# City of Albuquerque

October 17, 1985

REF: DRAINAGE PLAN FOR CARQUEST AUTO PARTS STORE (J14-D55) RECEIVED  
SEPTEMBER 17, 1985

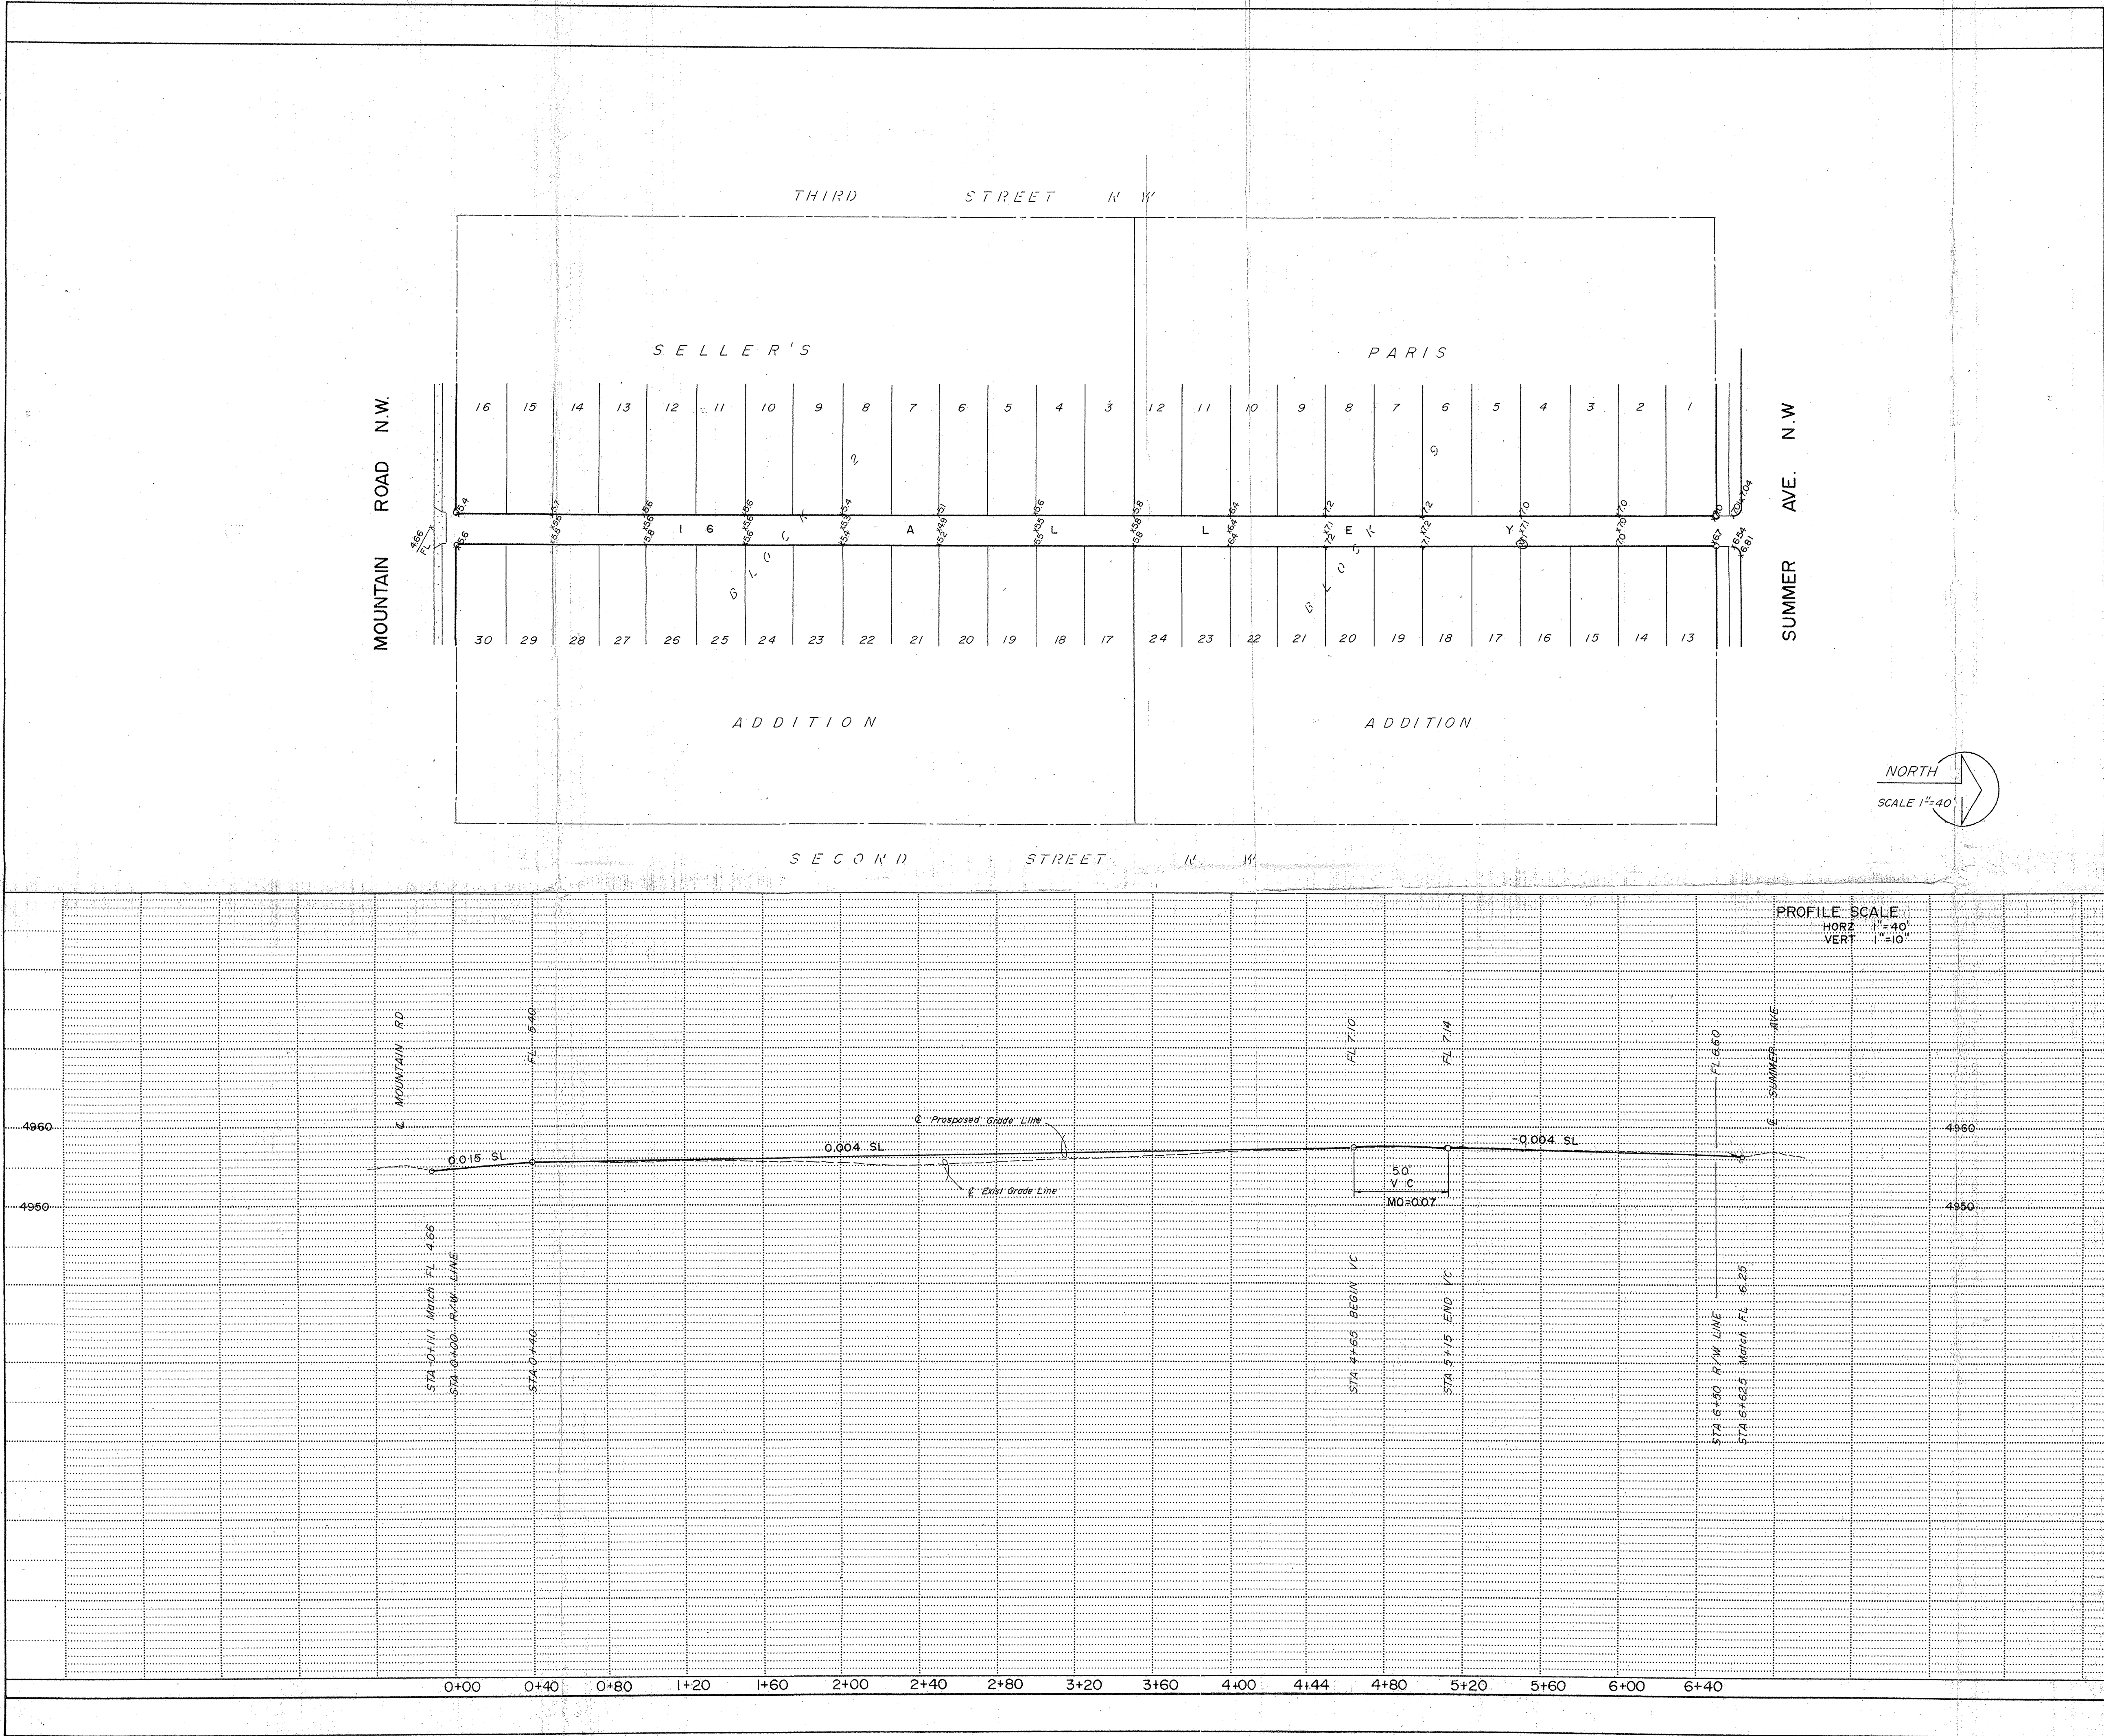
1. The status of alley grades and what your are proposing.
2. Status of lot line removal.
3. Floodproofing of the proposed office.
